WELWYN HATFIELD COUNCIL – DEVELOPMENT CONTROL
DELEGATED REPORT

APPLICATION No:	S6/2011/1869/FP
------------------------	------------------------

This application seeks full planning permission for retention of two side dormers (amendment to planning application S6/2011/0970/FP). The west facing dormer has been constructed in accordance with the extant planning permission. The east facing dormer has been increased in size from 3.2m in length to approximately 4.8m and a window has been added.

Drawing No:
110701.03

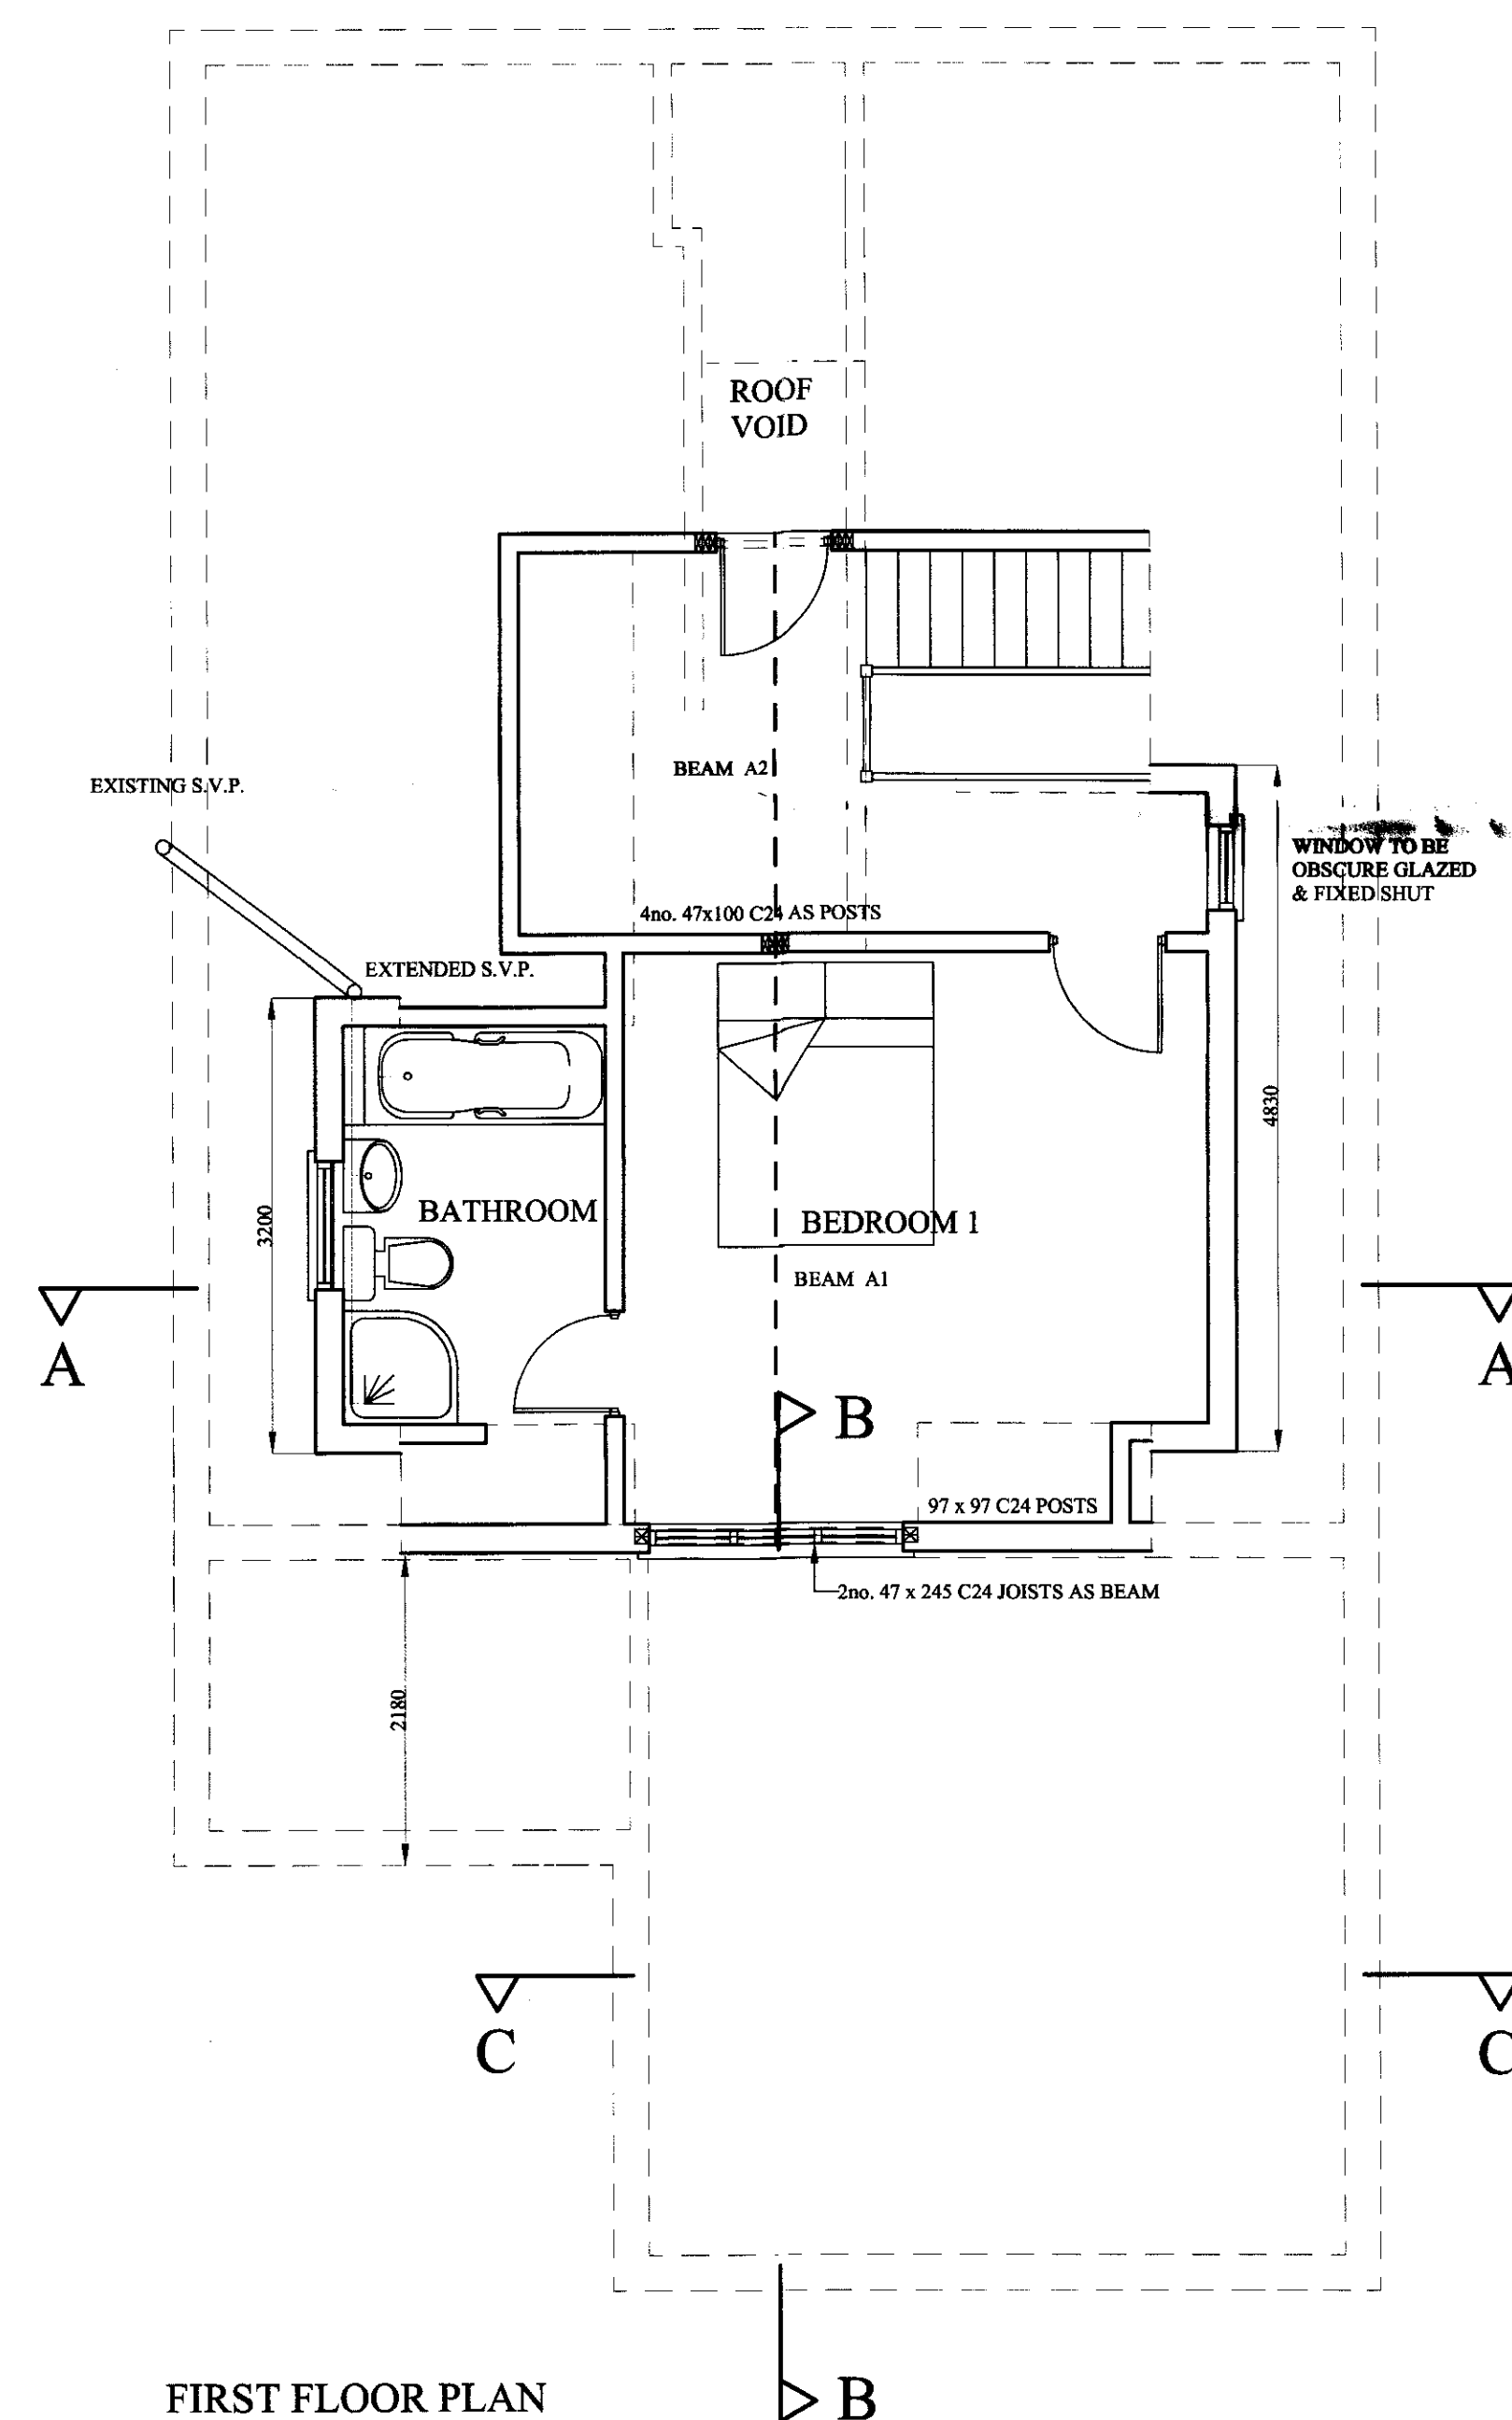
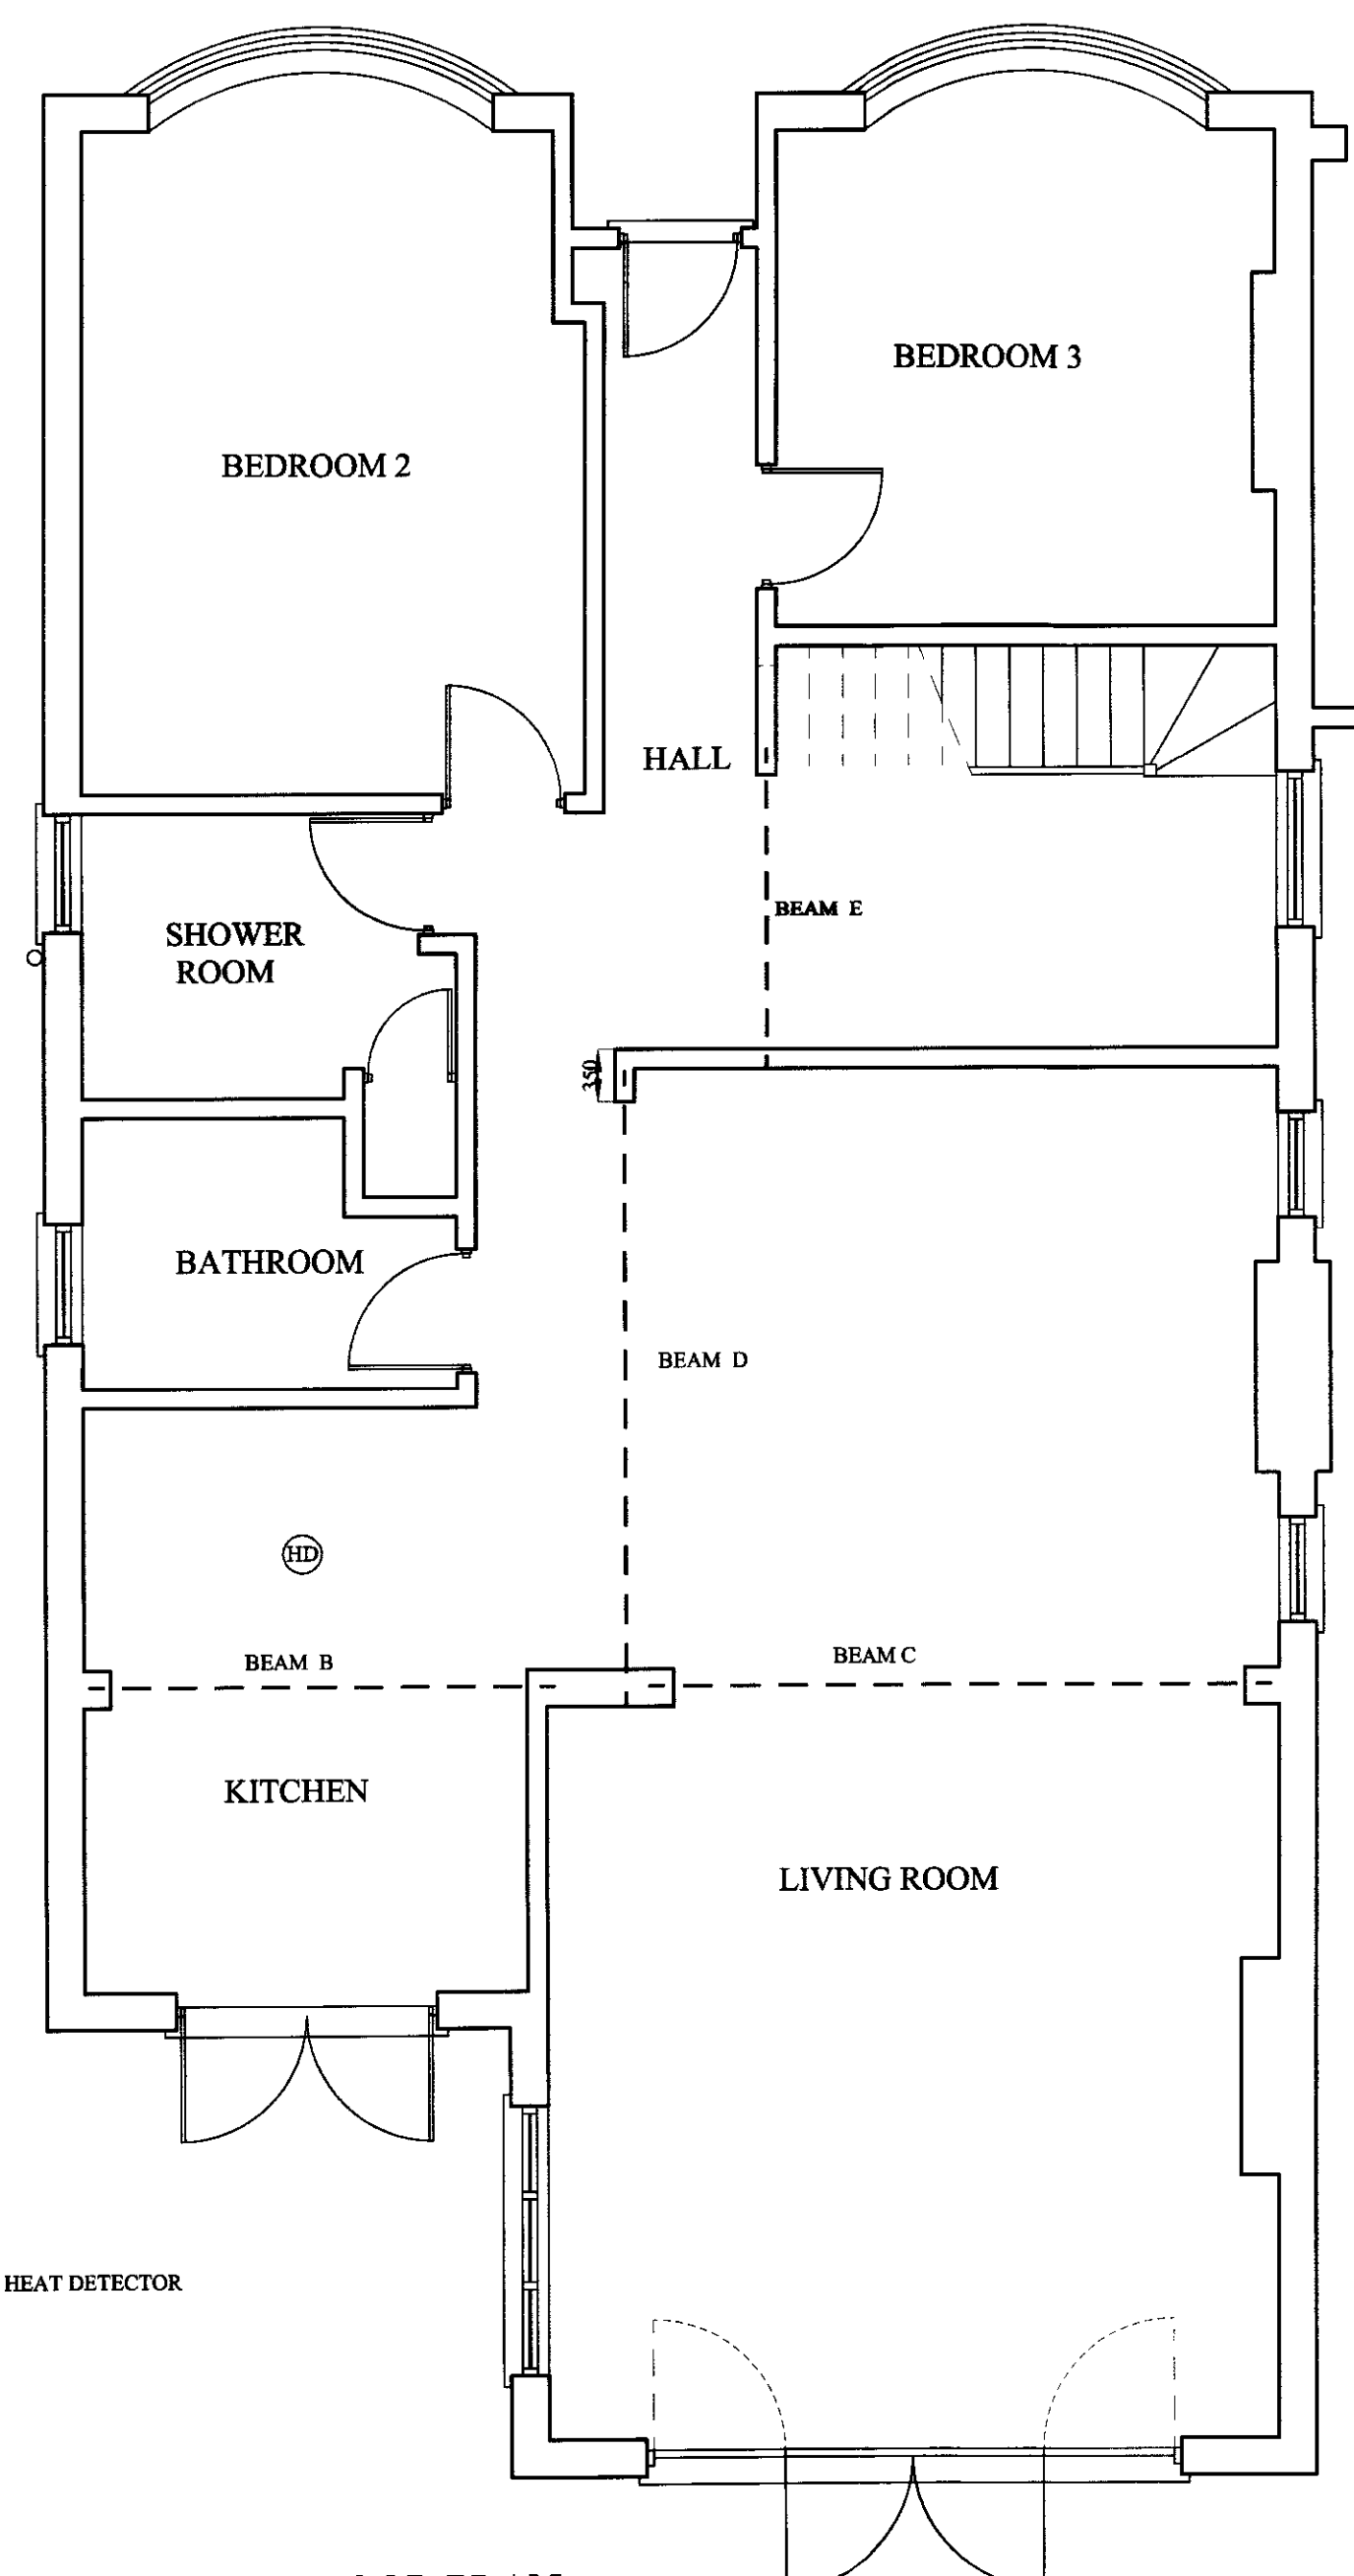
The application dwelling and neighbouring properties are detached and have a reasonable separation. The enlarged dormer does not appear overly dominant when viewed from the adjacent plots. One window is proposed within the enlarged dormer which would serve the first floor landing. Drawing No.110701.03 shows this window to be fixed and obscure glazed. The window within the west facing dormer serves a bathroom. To ensure that both windows remains obscure glazed a condition could be applied if consent is granted. The proposed development would not result in any additional overlooking or a significant loss of privacy to the adjoining

Drawing No: **110701.02 B**

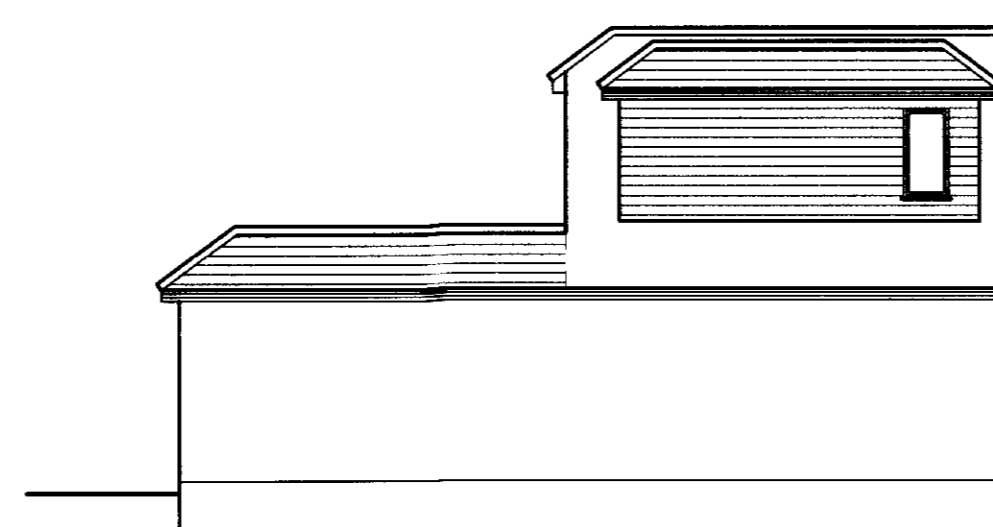
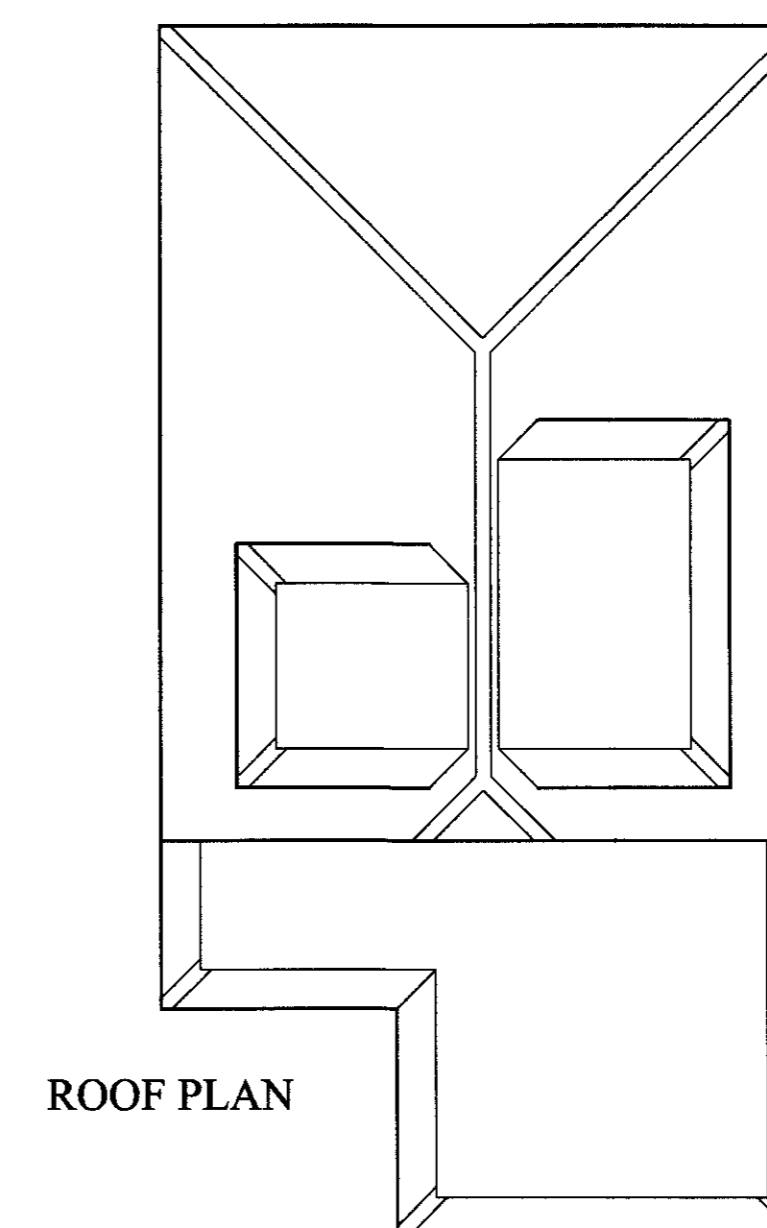
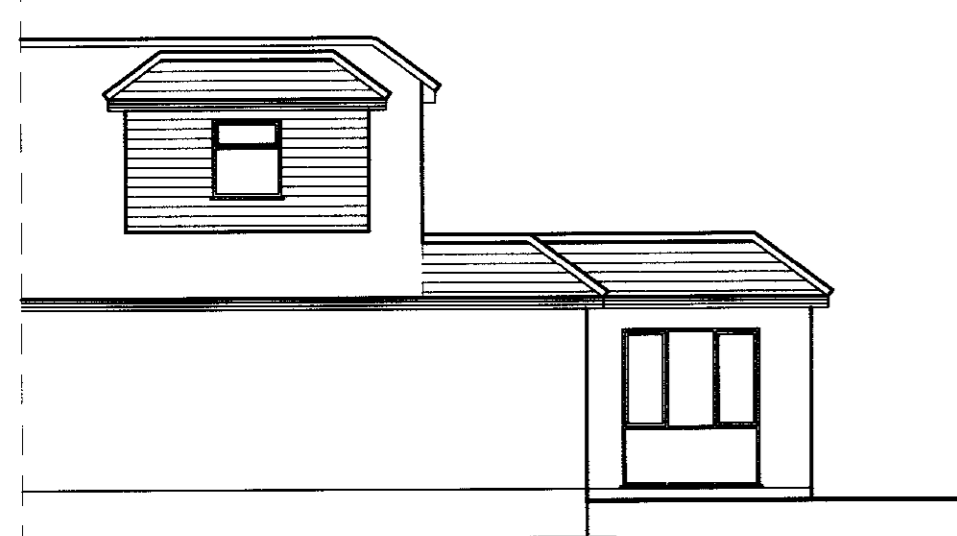
“The PC have concerns that this application makes a large addition to plans already granted and may cause overlooking implications for neighbours.”

Planning permission S6/2011/0970/FP granted consent for two dormer windows measuring approximately 3.2m in length, one on each side of the application dwelling. The east facing dormer has been increased in size to approximately 4.8m and a window has been added where previously no windows were proposed to this side. The enlarged dormer retains an acceptable distance from the edges of the roof and appears subordinate in scale. The scale and design of the dormer is similar to additions to other properties within the locality of the application site. The enlarged dormer does not appear overly prominent and does not have an adverse impact upon the character and appearance of the surrounding public areas over-and-above the extant permission.
